Our Ref: 0402A

OBJECTION TO SSD 98068713 - 65 MUSTON STREET, MOSMAN

Proposed construction of a part-8/part-10 storey residential development, with in-fill affordable housing, comprising: demolition of existing structures, site preparation and excavation, 13 apartments (including 3 affordable housing apartments), lower-ground and basement parking for 29 cars with access from Redan Lane, communal facilities and rooftop communal open space, associated civil and landscaping works
Applicant: Prosker Property Pty Ltd

- Site
- Spit Junction Town Centre
- Indicative LMR Housing Area
- Route: <400m to Site

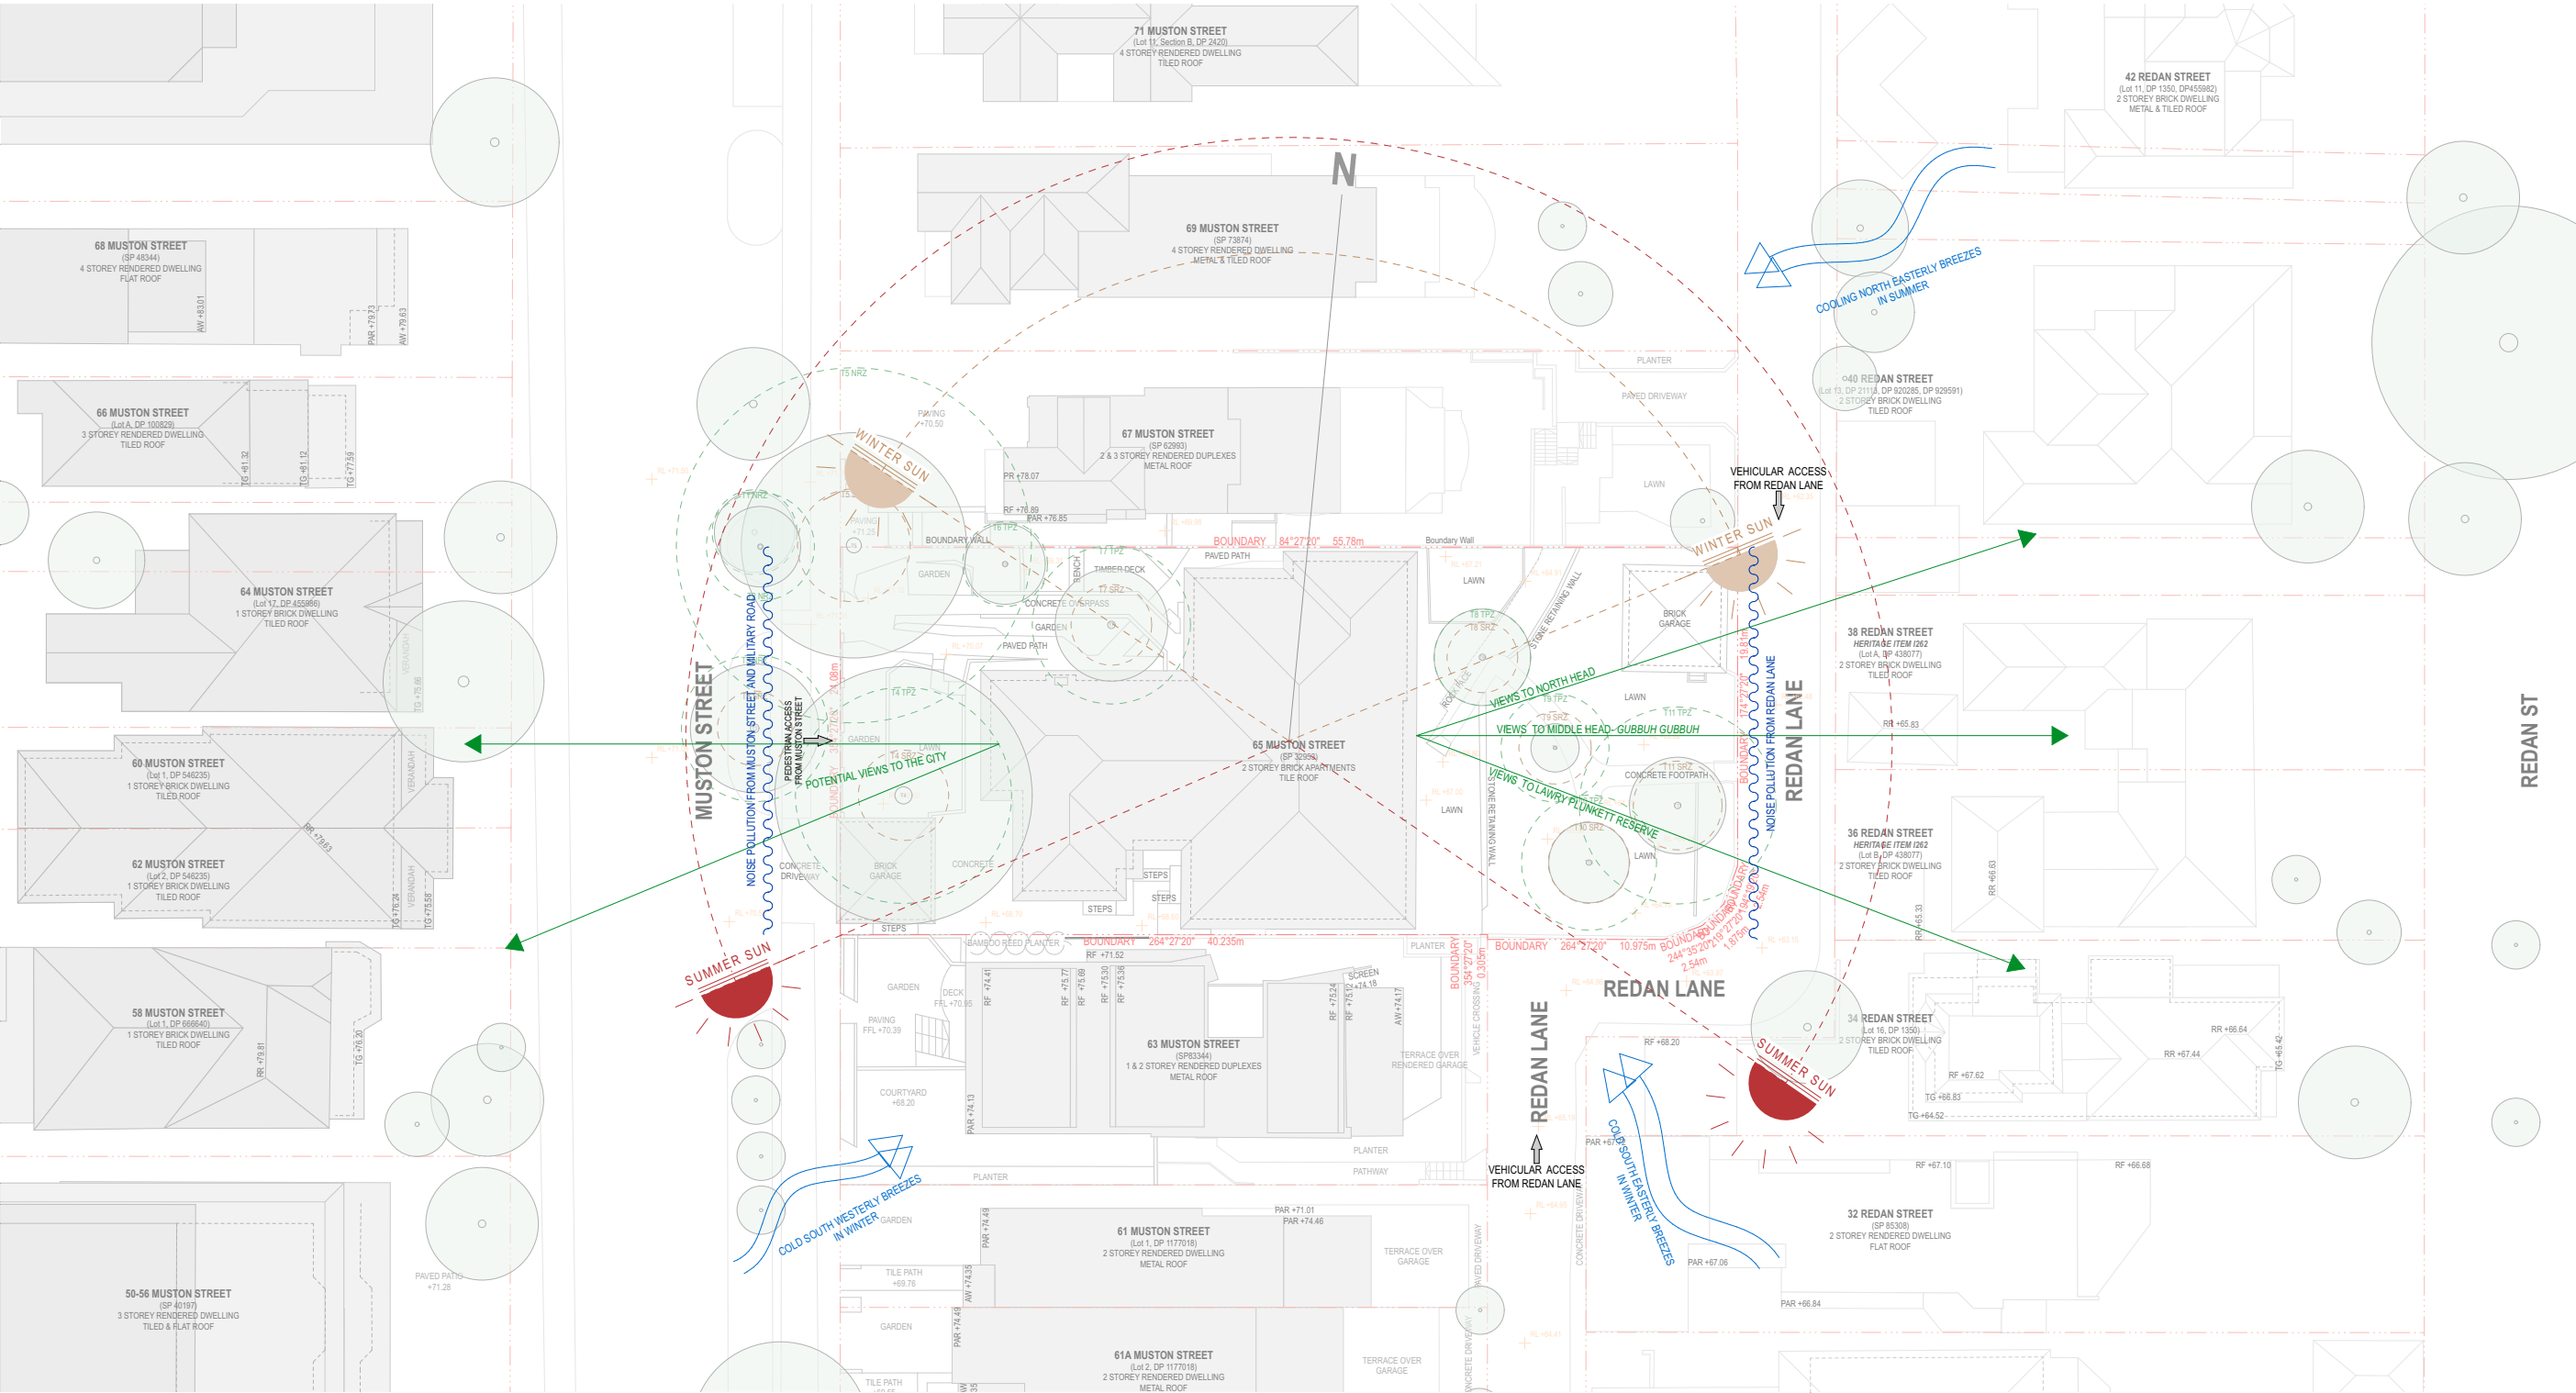
The EIS appears to rely upon an incorrect measurement (of less than 400m which omits use of the available pedestrian crossing, which has been used to inadvertently characterise the site as falling within a 'low and mid rise housing inner area' (as defined).

The survey report relied upon by the Applicant provides a route that requires pedestrians to cross Almora Street in the absence of an existing pedestrian crossing and cannot therefore not be used to calculate the walking distance. The pedestrian crossing located at Almora Street and Military Road should be used as the travel distance which therefore puts the site outside of the required 400m for an LMR inner area.

Shadow Diagrams - Maximum Building Height + Bonus (28.6m)

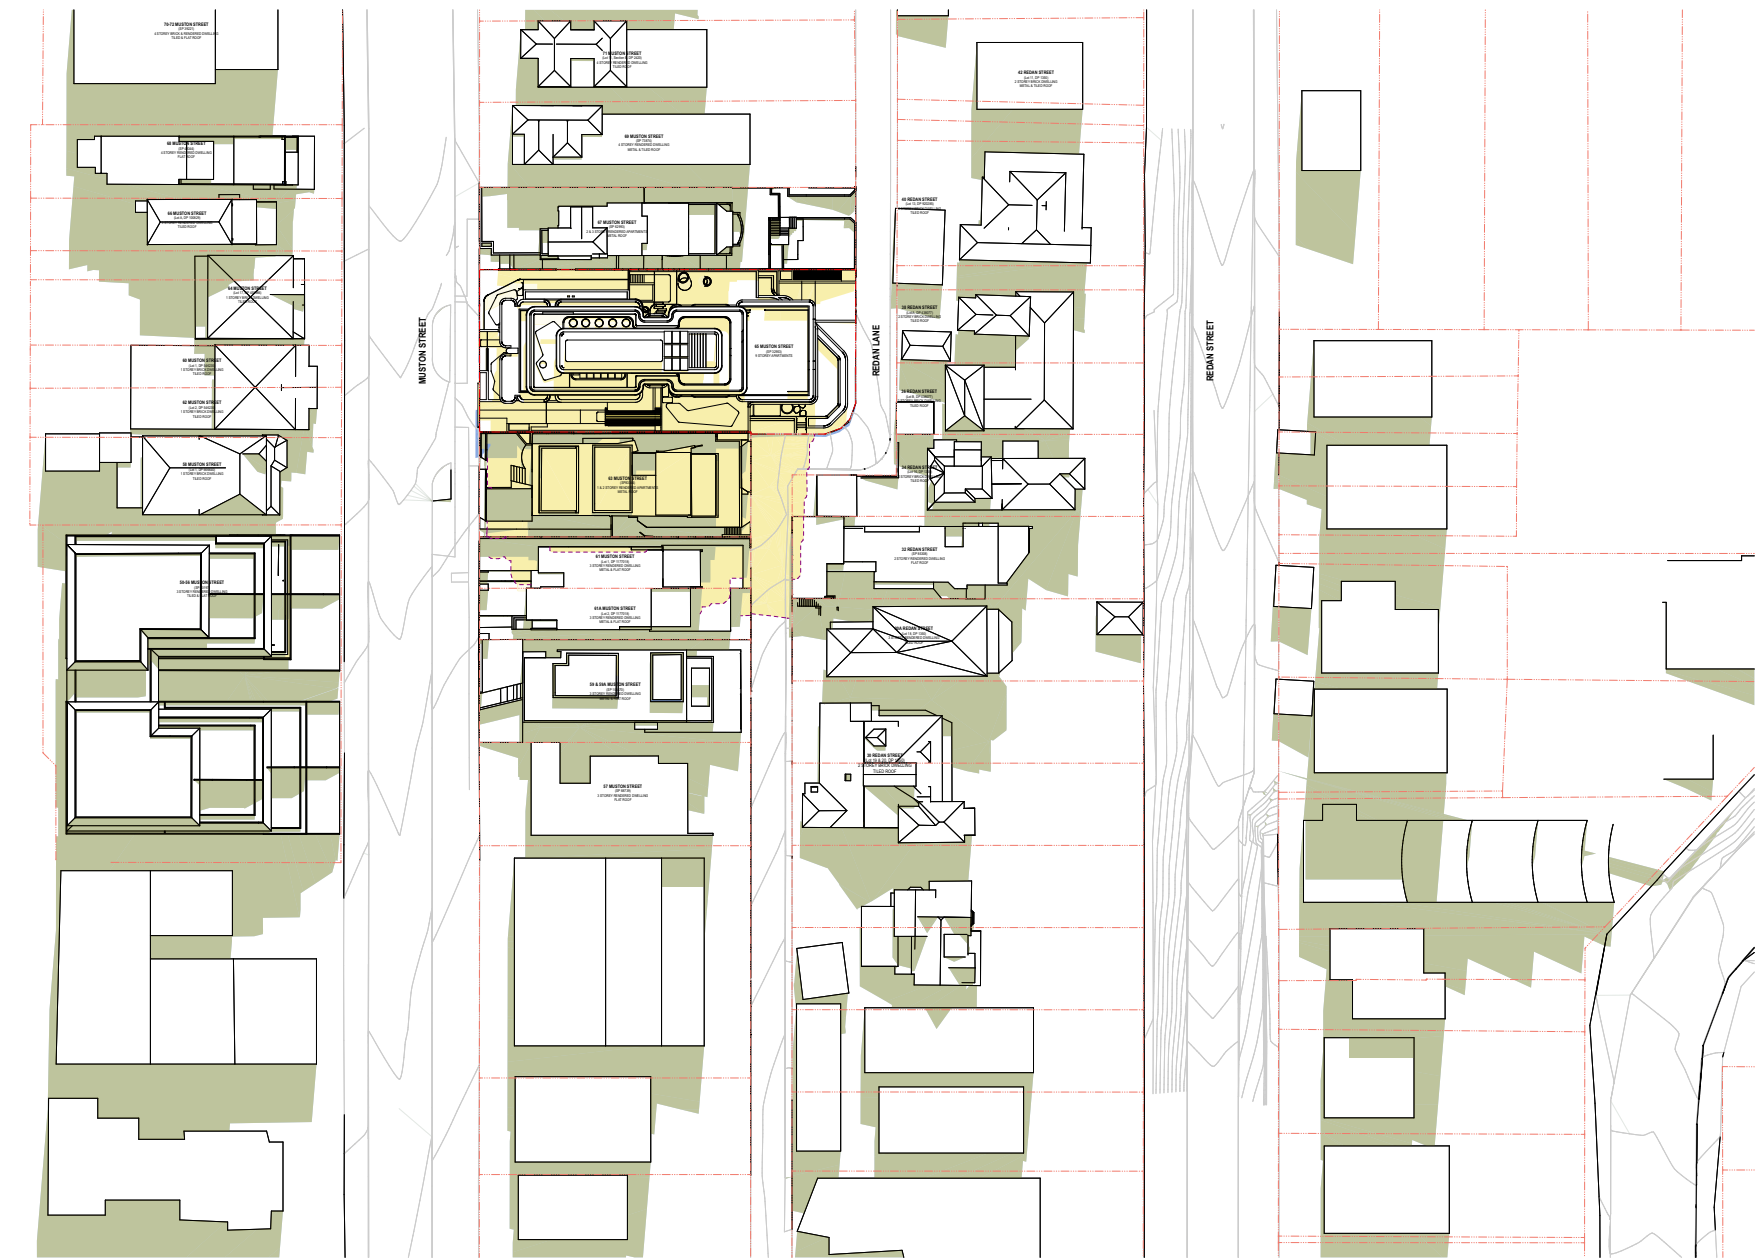
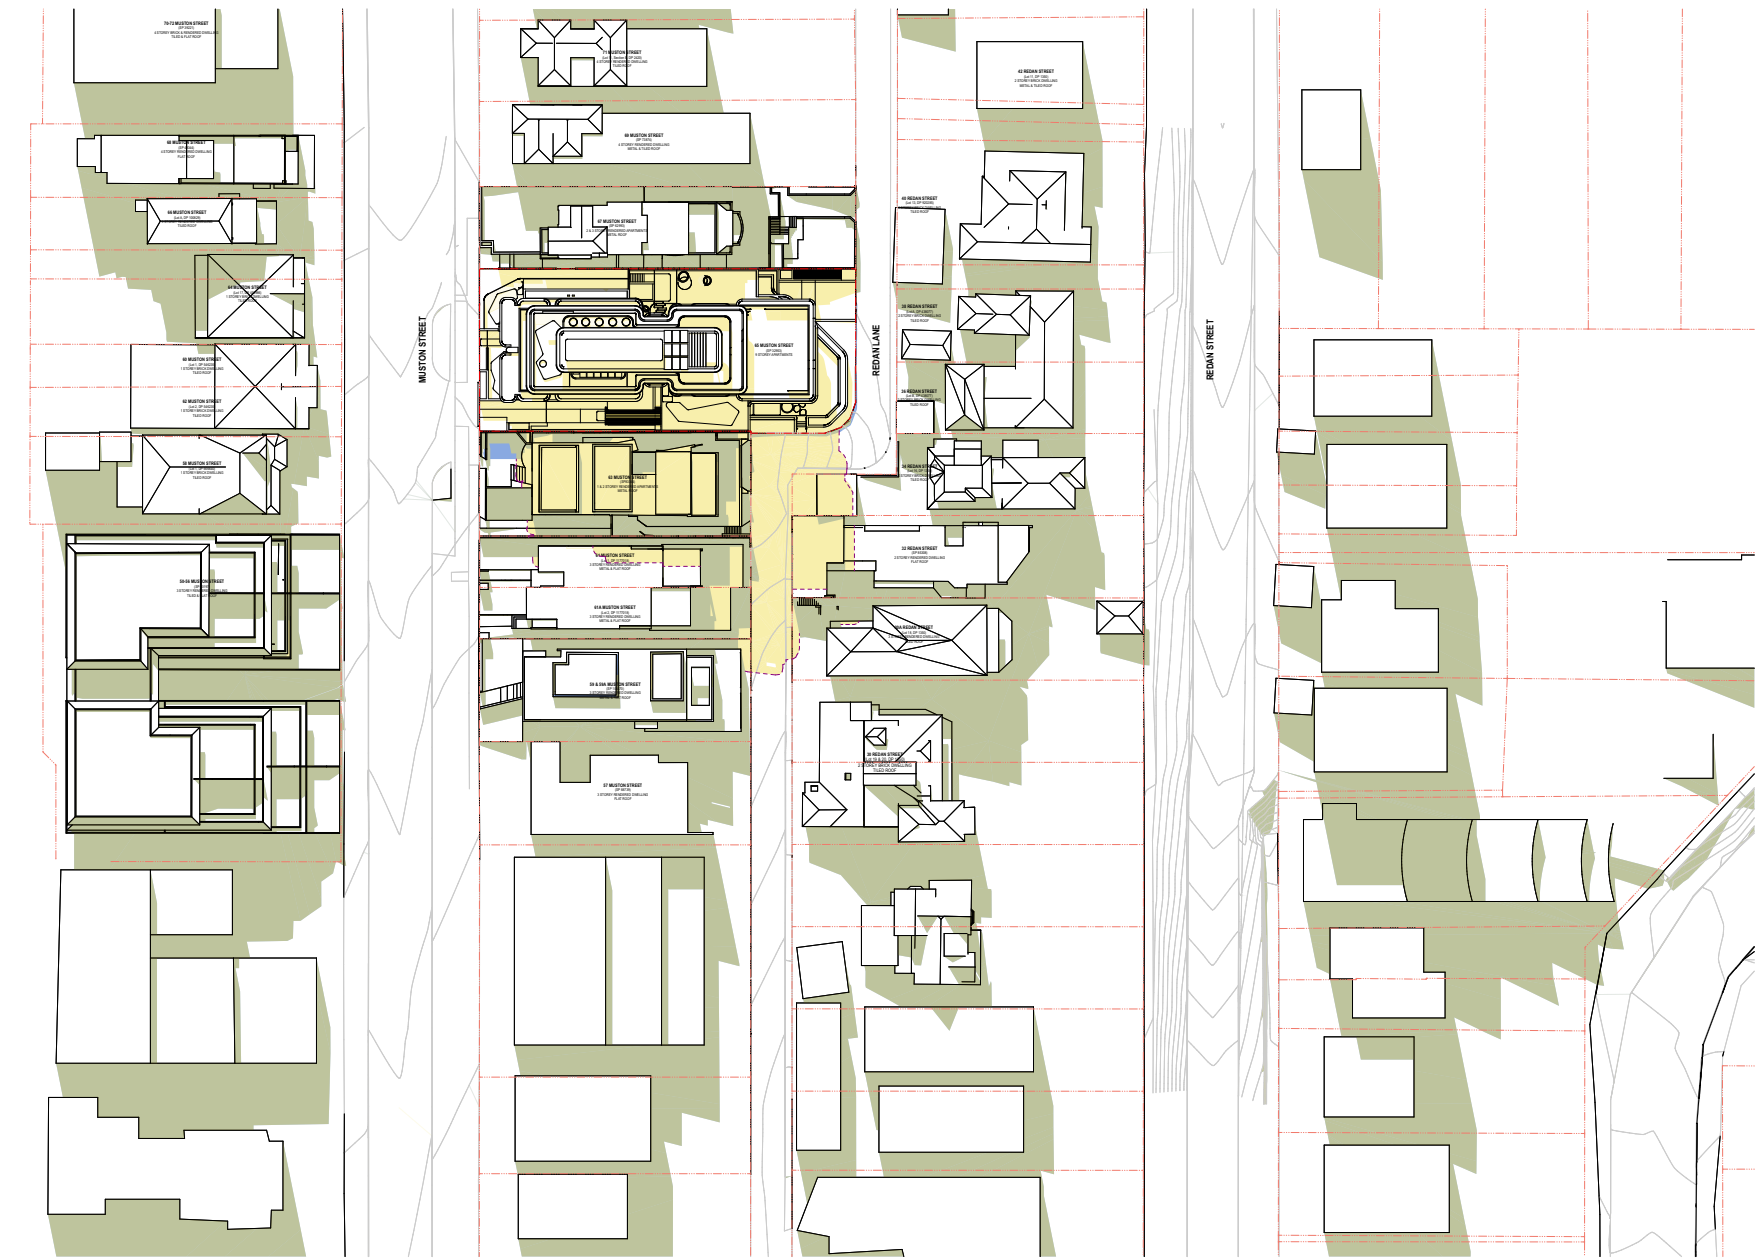
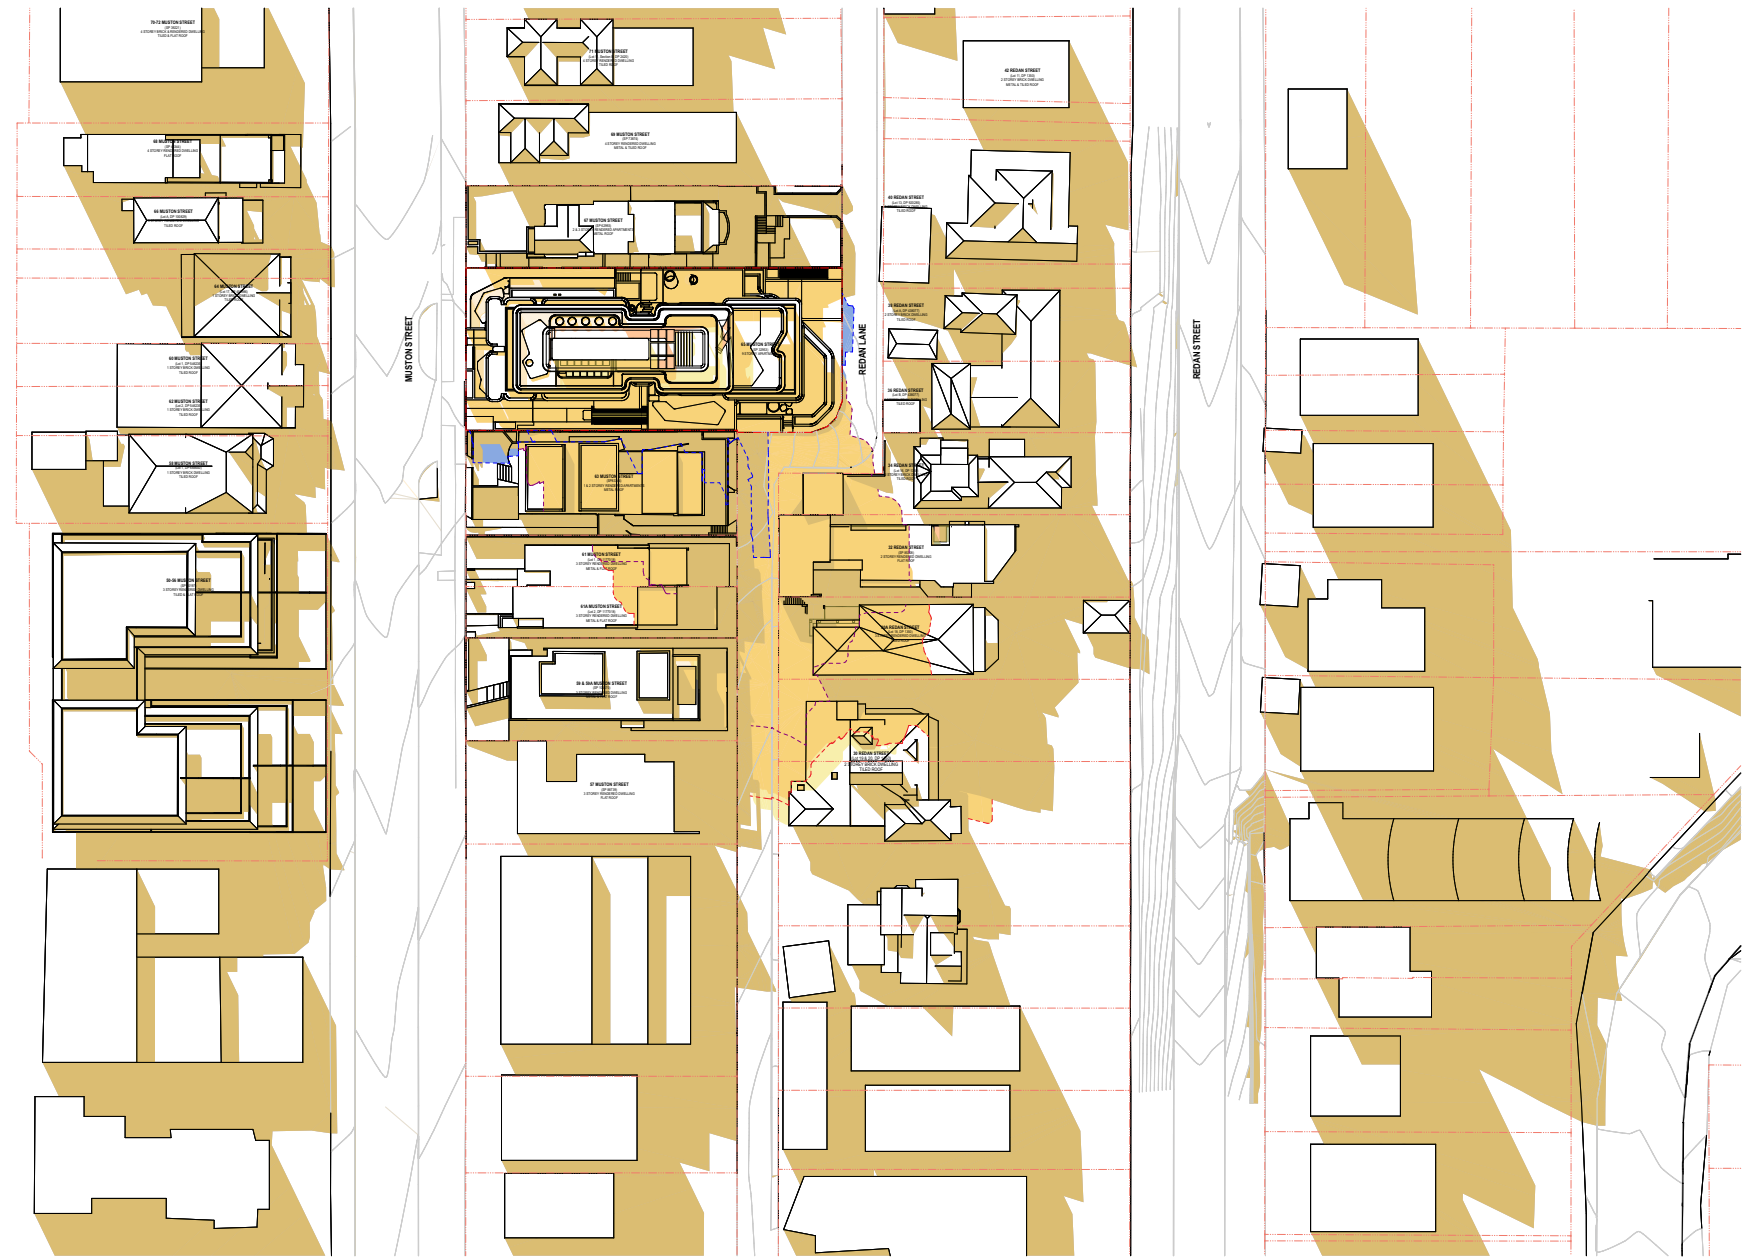
Under the Housing SEPP, development within the R3 zone that is within 400m of a nominated centre is permitted to have a maximum height of 22m, plus the 30% bonus height permitted under the Housing SEPP. However, section 176 of the Housing SEPP is the correct provision that applies to the site given that it is located within a low and mid rise housing outer area and sets a maximum building height of 17.5m as follows:

For clarity, the permitted height under the LMR provisions within Chapter 6 of the Housing SEPP is therefore 17.5m, not 22m. Similarly, the maximum FSR is only 1.5:1, not 2.2:1. The development proposes a significant increase over these controls, and then some – by proposing an FSR of 2.58:1 and a maximum building height of 31.68m – whilst attempting to formalise this in the absence of environmental planning grounds as part of clause 4.6 requests (albeit without addressing any breach in the number of storeys).
